CROWE SUBDIVISION FILING NO. 1

MINOR SUBDIVISION PLAT
CROWE SUBDIVISION FILING NO. 1

MVE PROJECT: 61138
MVE DRAWING: 61138-PLAT-PS
DATE: AUGUST 2, 2021
SHEET: 1 OF 1

MINOR SUBDIVISION PLAT CROWE SUBDIVISION FILING NO. 1

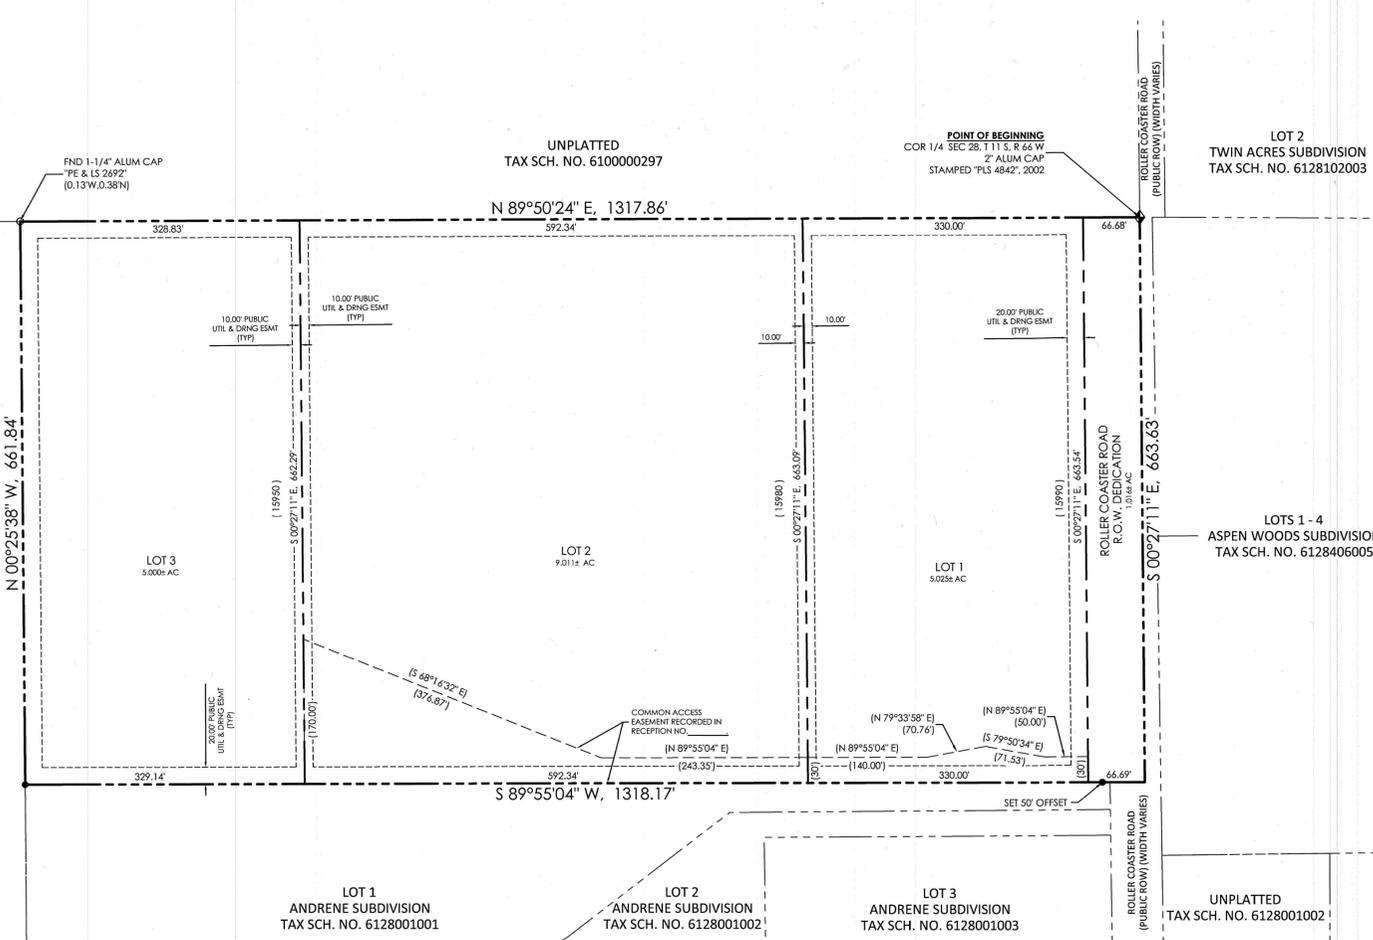
Previous redline: the soils and geo report seem to call for perimeter drains but there is no plat note. please add plat note.

Previous redline: please add the name, address and telephone number of the owner of record located in the lower right hand corner
